**Powerhouse Ultimo Renewal – Concept State Significant Development Application (SSD-32927319)
Response to Request for Information**

Attachment 1 – Response to GAO Feedback

## 2.12 Public Space Requirements

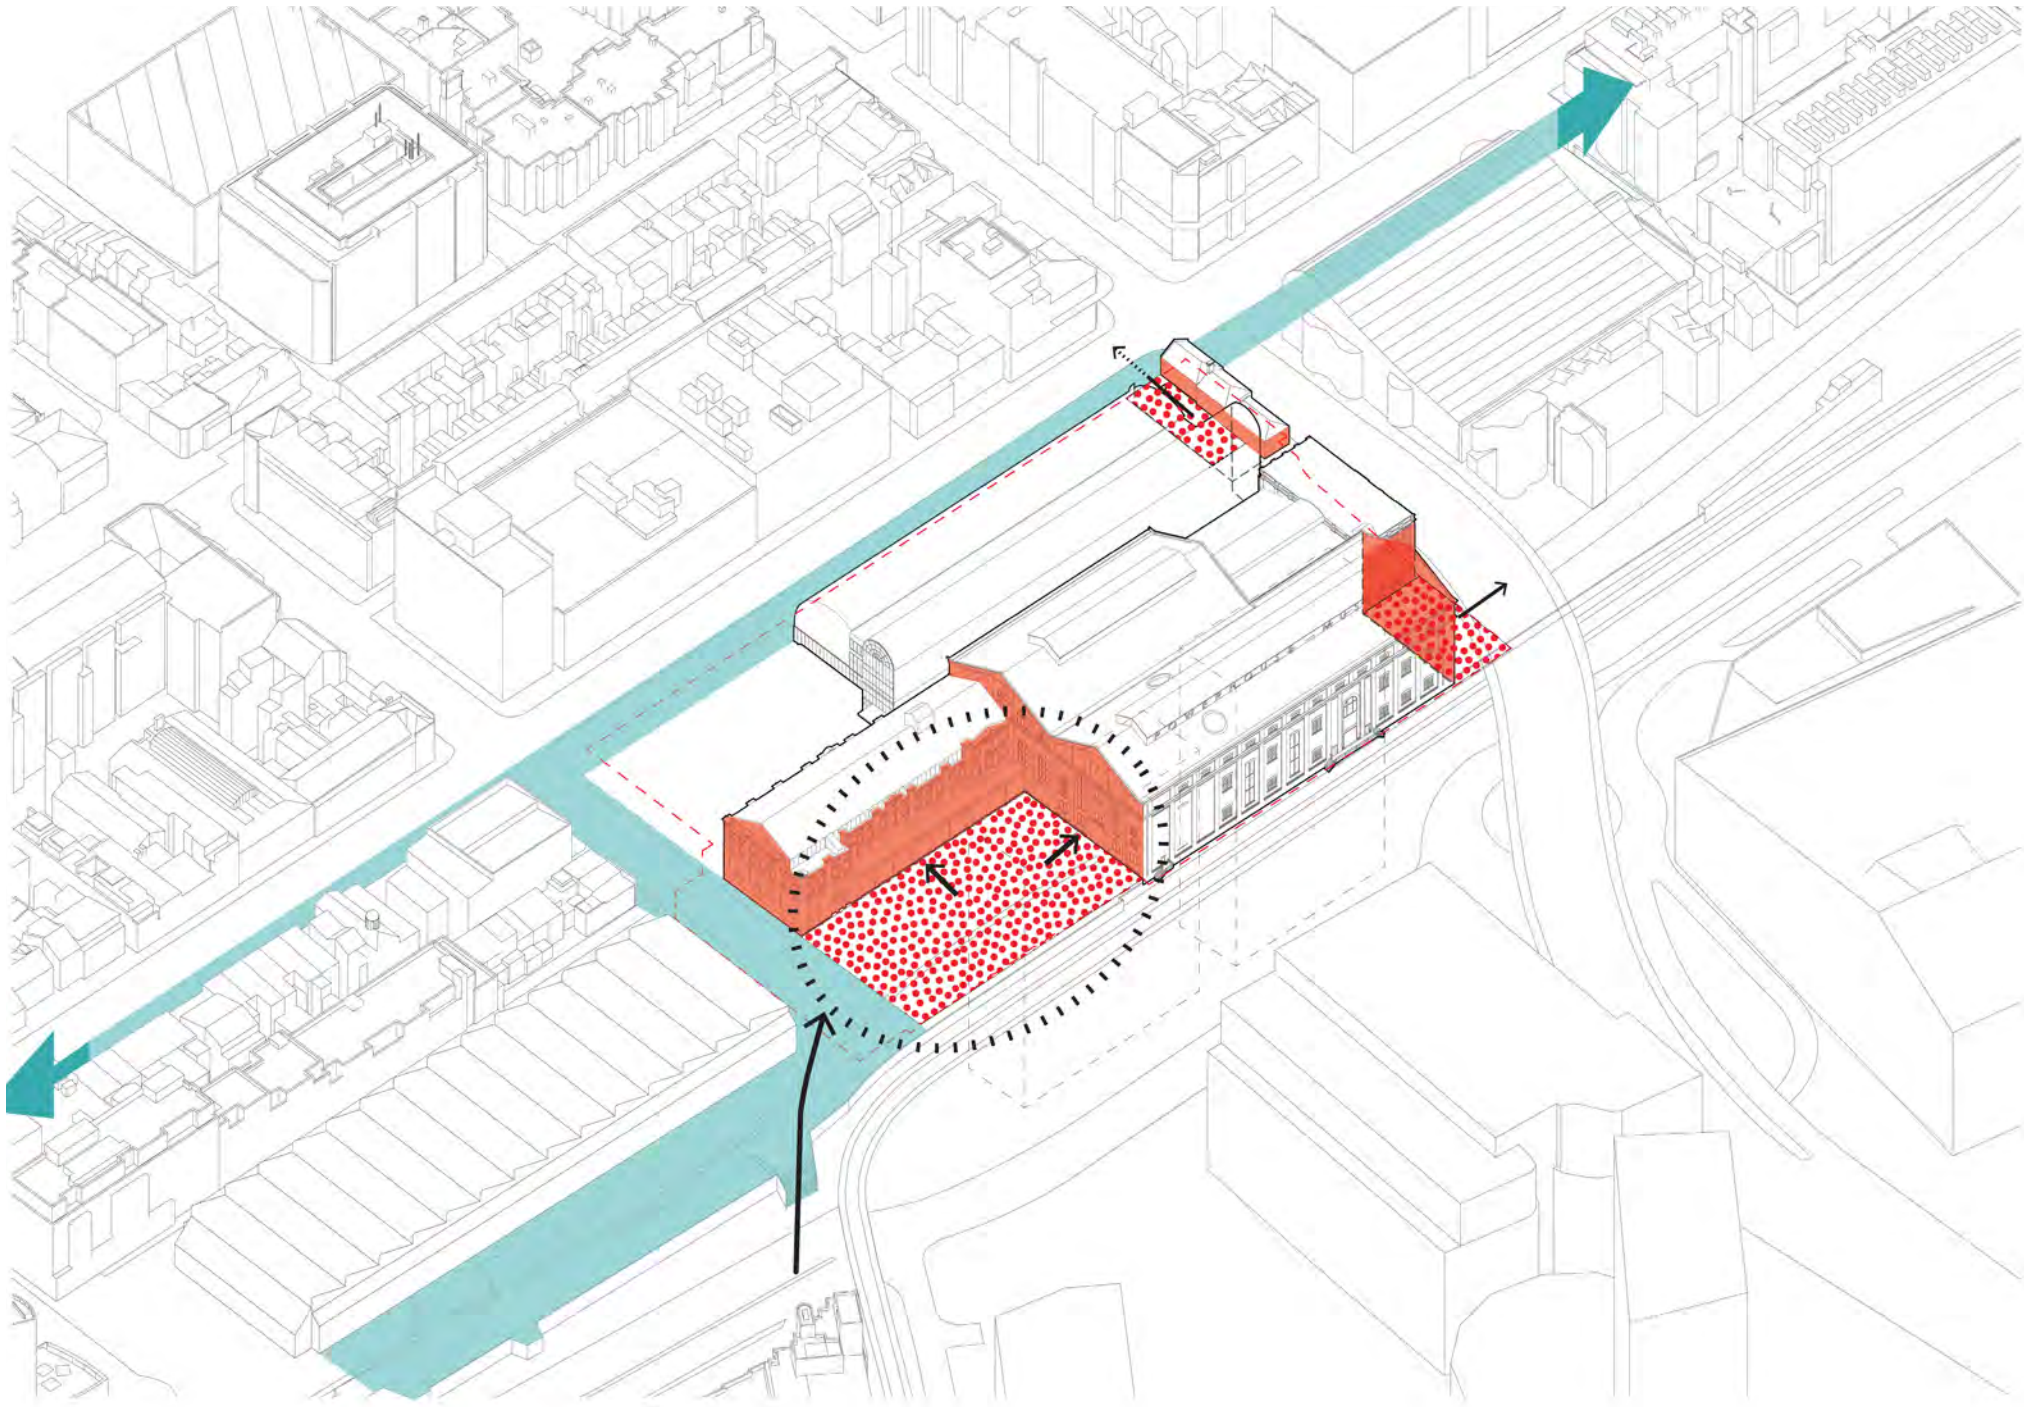
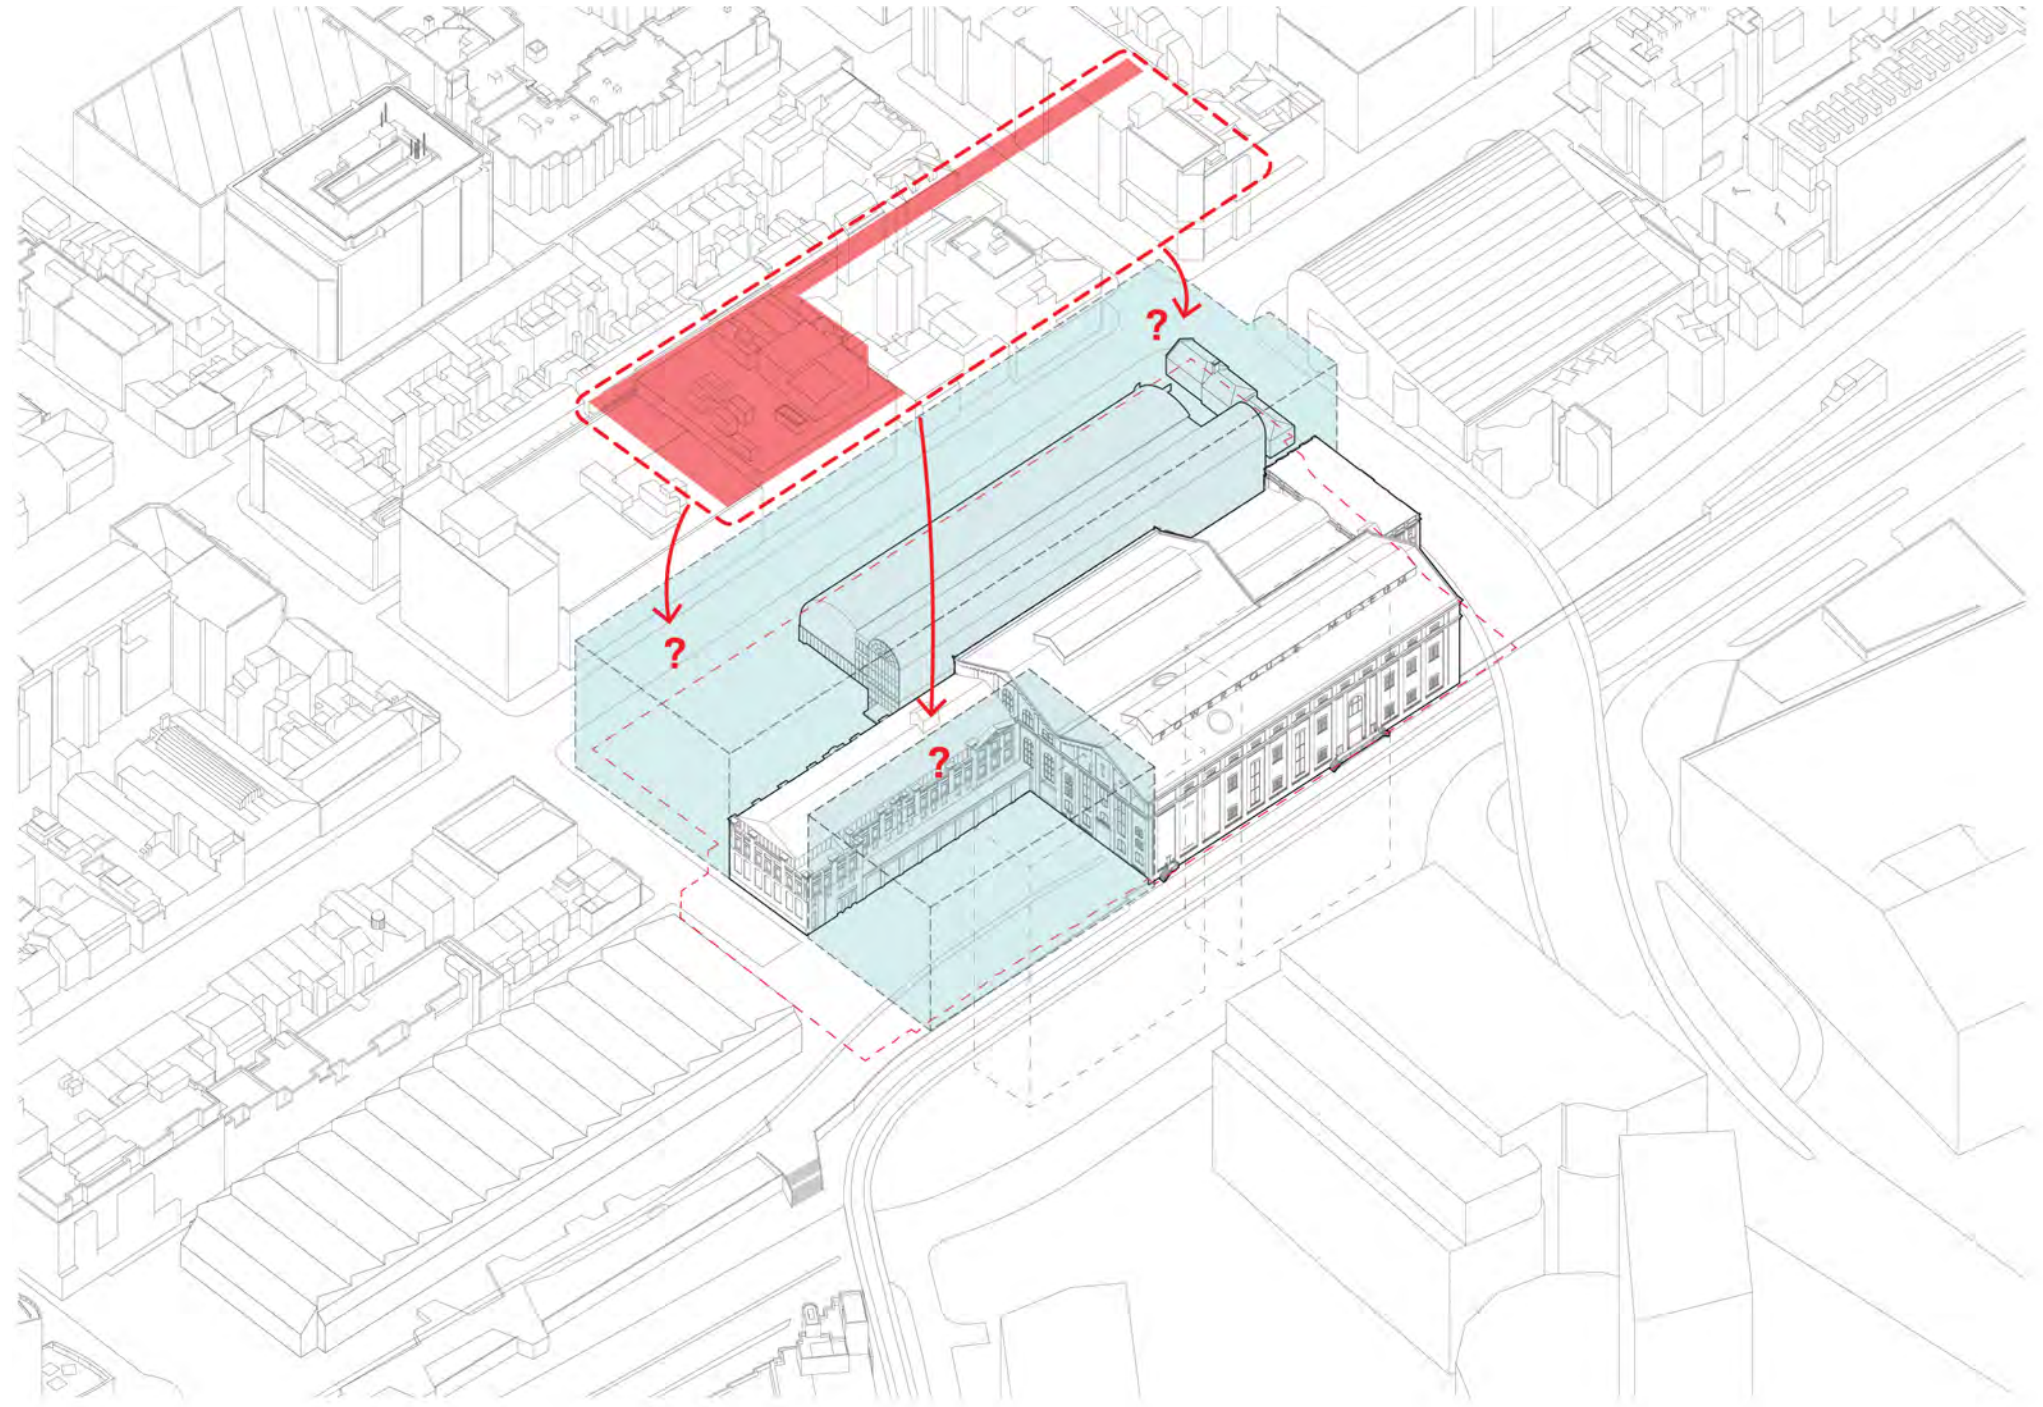
Public Realm and Open Space	
There is no indication of the scale of the proposed quantum of public open space in relation to the size of the site. The documentation should be accompanied by a drawing which clearly defines what 2,200sqm and 1,800sqm looks like on the site.	Drawings provided with the Building Envelope Plans are provided to scale, and these areas are readily able to be measured accordingly. This can be conditioned if required.
Update bullet point 5 – to read: ensure the open space is accessible	Suggested change made at Attachment 2 .
Update bullet point 8 to read prioritise pedestrian use	Suggested change made at Attachment 2 .
Update bullet point 9 and 15 to read: demonstrate solar access is maximised to public open spaces, and add: balancing the need for shade. The existing provision of solar access is unclear. Update the site analysis to identify the quantum of solar access the existing site achieves (and for how long). This should form a minimum commitment in the guidelines, with an ambition to increase and maximise solar access.	Suggested change made at Attachment 2 .The suggestion regarding updating the site analysis can be conditioned if required.

### 3.11 Zone 3 Guidelines

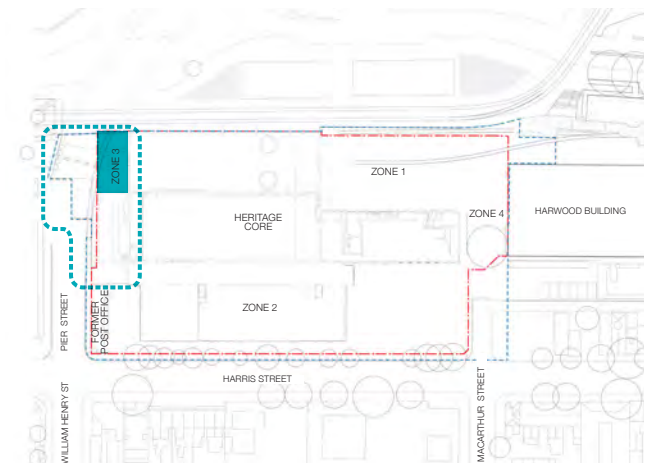
Zone 3 Guidelines	
The aspiration for this zone to enable a direct connection with the Pier Street underpass appears to be challenged by limited	The Applicant can only undertake works on land within its ownership and within the project boundary. The EIS identifies the extent of land which is within the site boundary and the Applicant's control, as well as the ownership of surrounding land. It is clear from the

GAO Comment	Proponent's Response
analysis of the connection in terms of ownership, physical constraints, interfaces, and opportunities etc.	application that there is a commitment to work with other parties to progress the potential for such a connection, noting no further analysis will assist in achieving an outcome in this regard.
The Setbacks and Built Form Expression section should be expanded to address the visual / physical curtilage and setting of the adjoining Heritage Core fabric and include guidance relating to its protection and to ensure that any proposal does not dominate the Heritage Core buildings or impact their legibility and setting.	It is unclear how such a limited envelope in this location could dominate the Heritage Core when it will not be seen from any vantage point apart from looking down from the Pier Street overpass.
Expand on what is meant by 'managed access' – including when and how this connection might be restricted and by what means?	This can be conditioned if required, but is more appropriately dealt with in the future assessment of specific proposals as part of the Stage 2 SSSA.
